From: Anita Gardner
Sent: 30 January 2019 14:16
To: Planning.Responses
Subject: FW: LU/328/18/PL 90/91South Terrace, Littlehampton

Anita Gardner | Principal Planner, Directorate of Place, Arun District Council | Location: First Floor, Arun Civic Centre, Maltravers Road, Littlehampton, BN17 5LF

Section AA

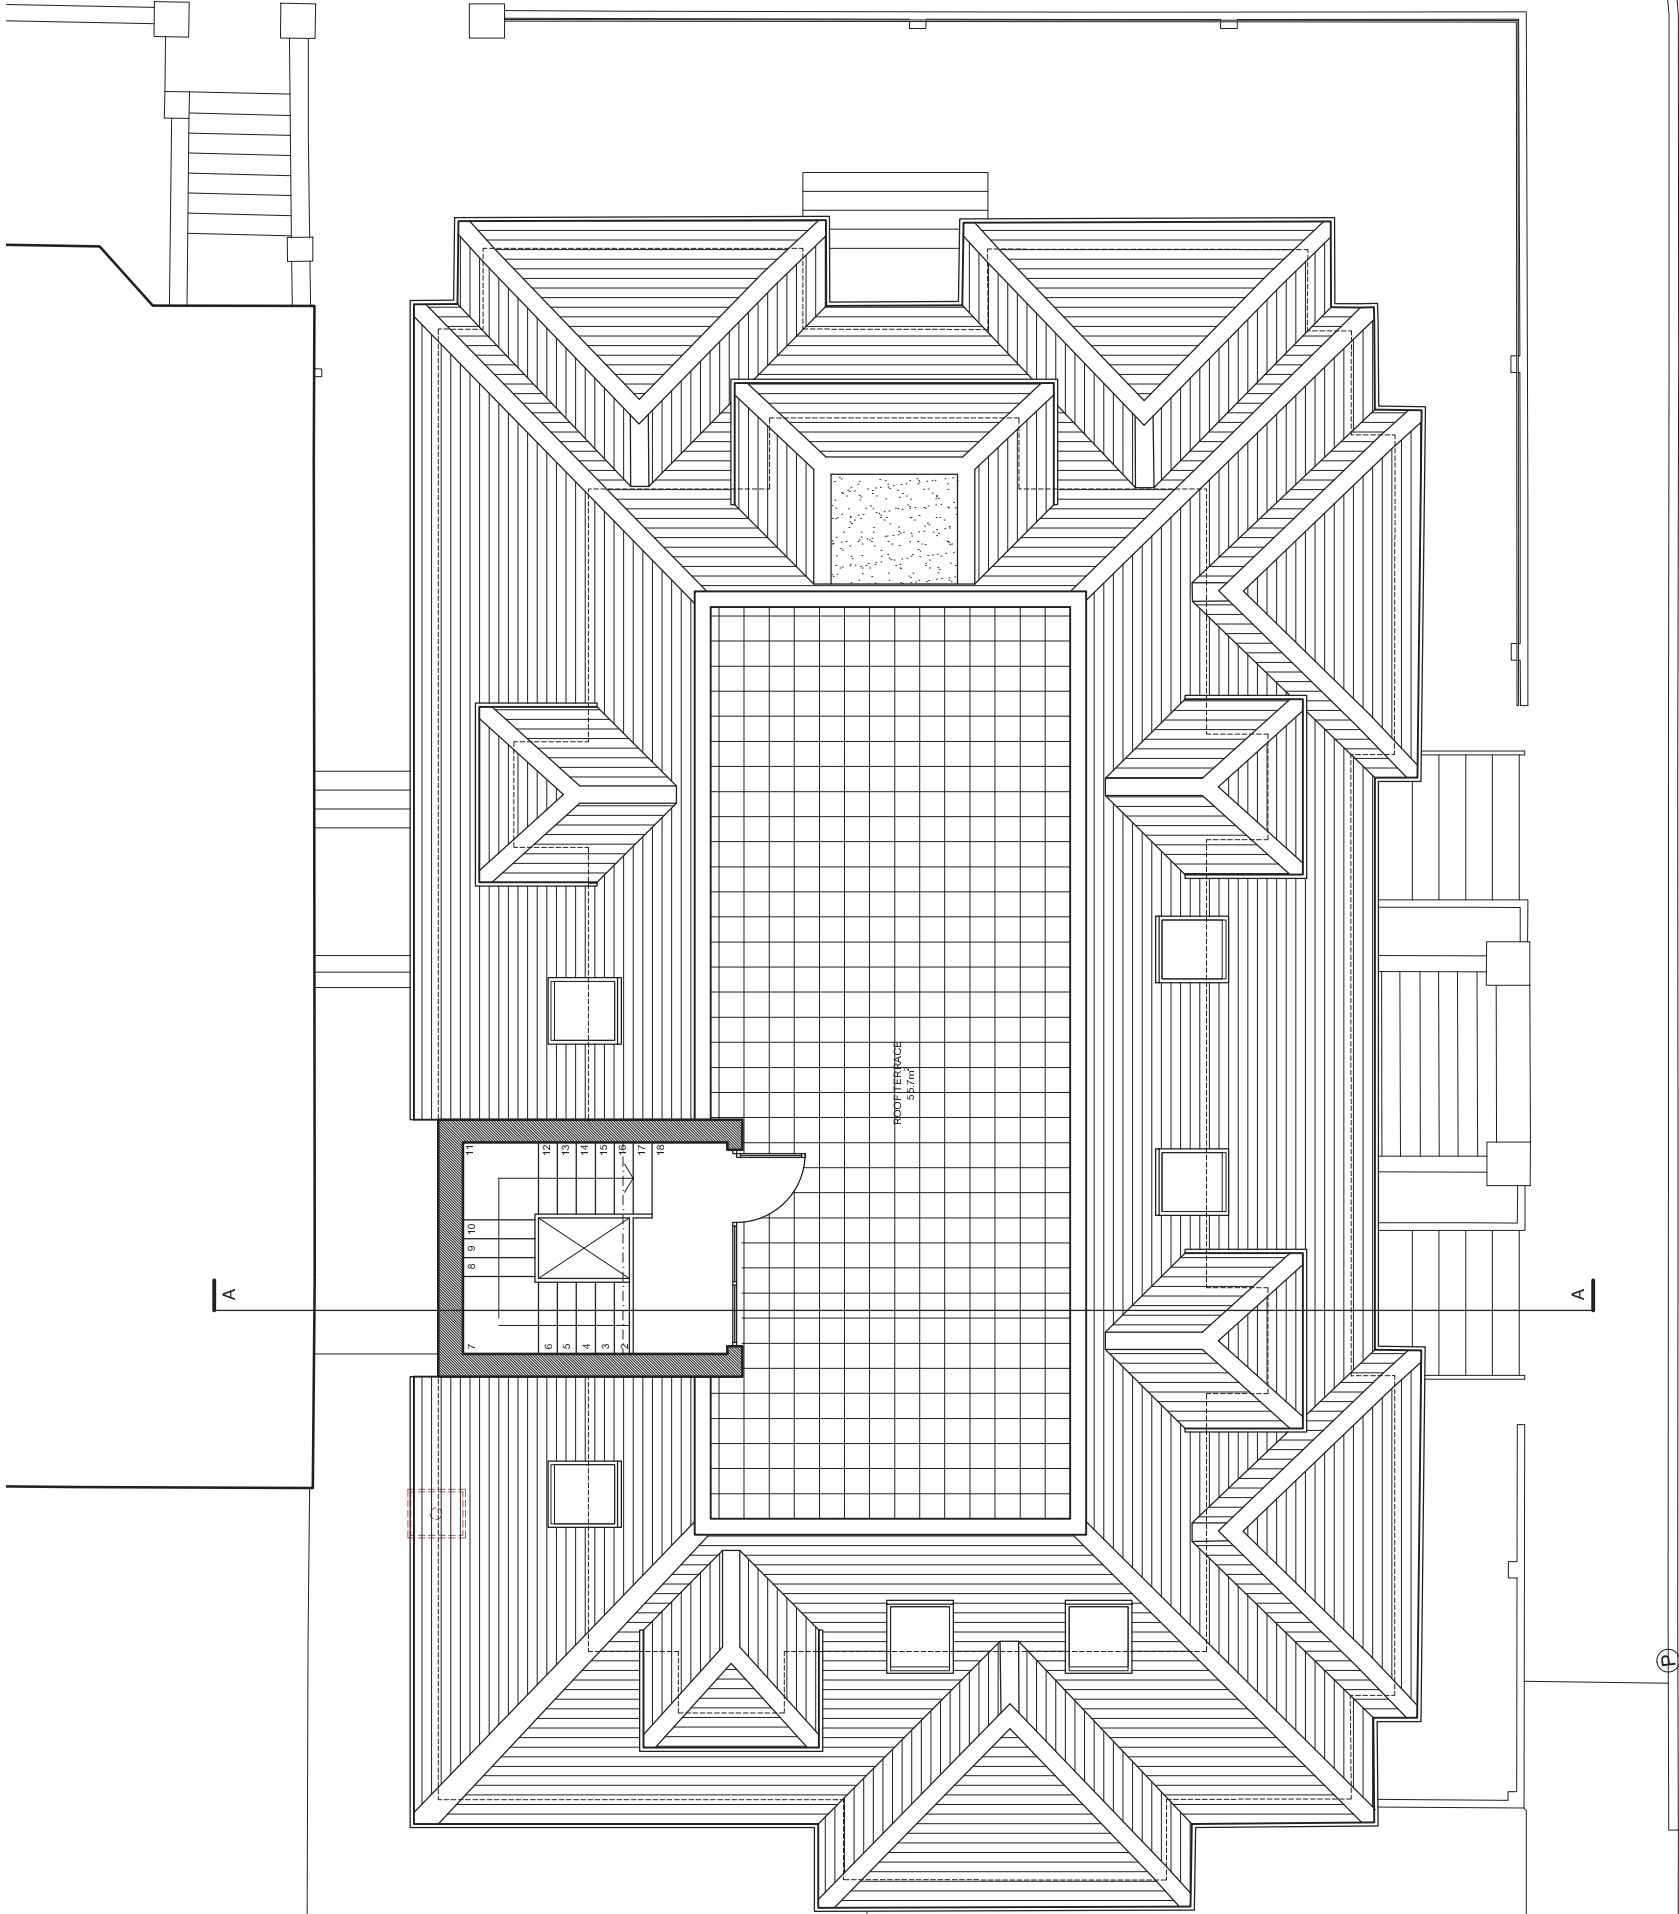
Further to the below, it has been just been drawn to my attention that there was one more error in Grahams original drawings (submitted under REF: LU/197/17/PL) that I missed when translating the drawings into CAD.

The stair access to the roof terrace did not stand tall enough to give the inhabitants sufficient head height (minimum 2m) when climbing the final flight. I have amended the drawings to allow for this head-height, the impact of this on the scheme is the roof terrace access stairs now protrudes a further 500mm onto the roof terrace. I have also added a gutter and downpipe onto the stair access, visible on the east elevation.

Please see the amended drawings attached. The alteration will be most readable in Section AA.

Section AA

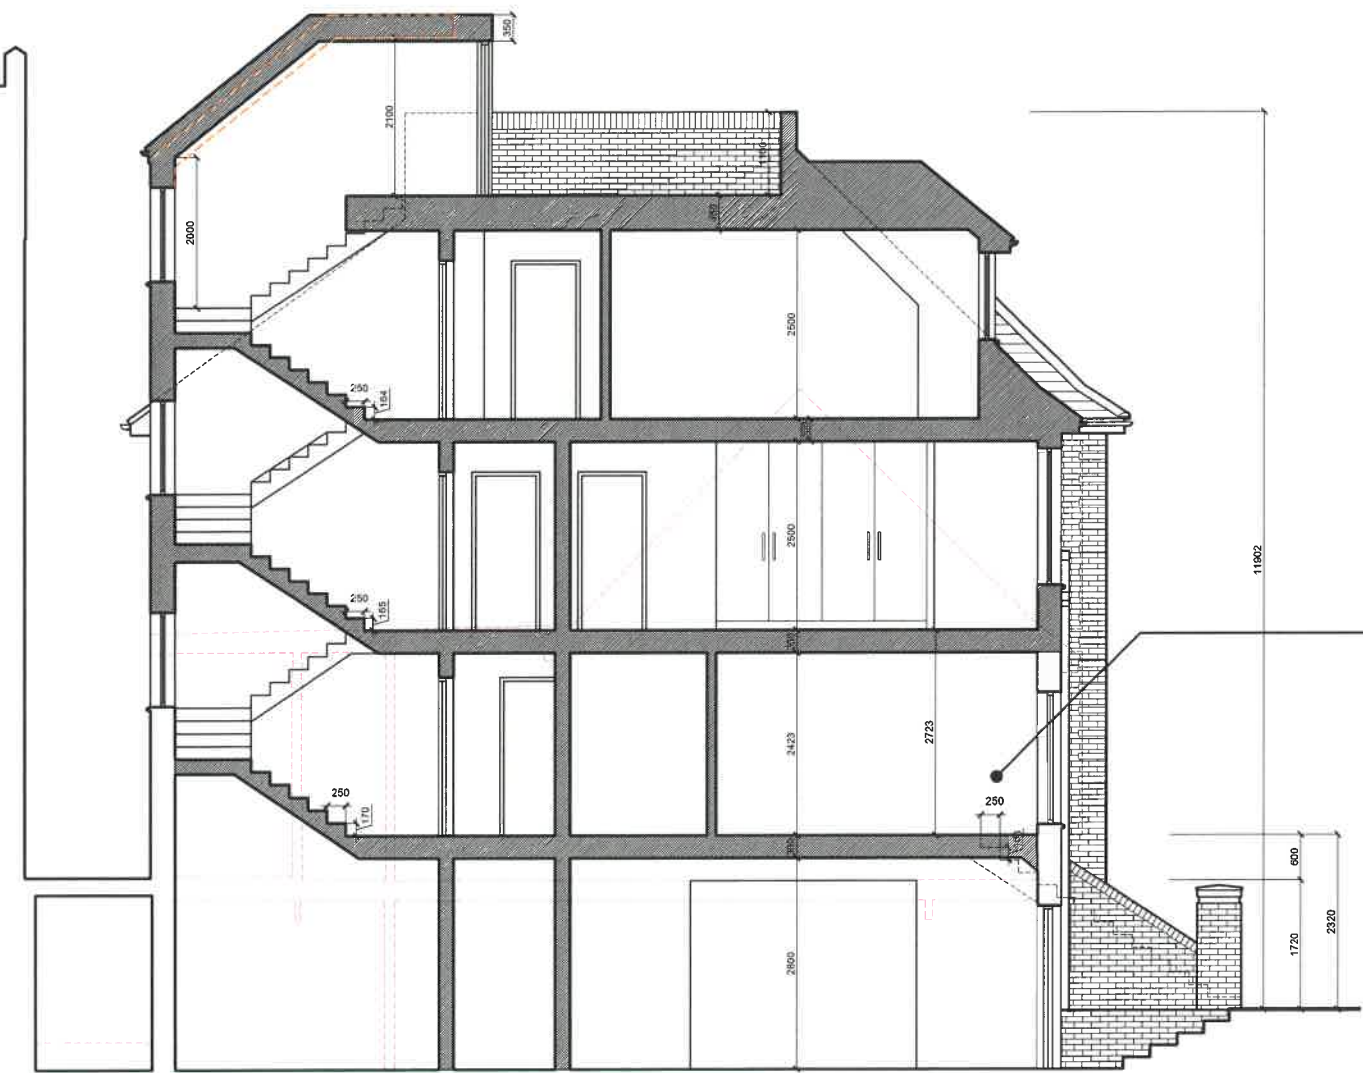
"I note that reference is made to the removal of the upper ground floor south facing balcony and French windows within the Design and Access Statement. However, they still appear on the plans and it is not clear which approach is correct. I am of the opinion that the balcony and French windows should remain as part of the scheme, and would enhance the elevation".

I'm afraid the Conservation officer is slightly miss-reading the drawings as the plans show the French doors and balcony being removed, as does the south elevation. Regardless, I have now amended the drawings pack and the DAS to reflect the re-instatement of these features. Please note that due to the increased FFL of the upper ground floor, the balcony is now positioned higher in the elevation. I have also included a note relating to the proposed roof lights being of a conservation style - see attached.
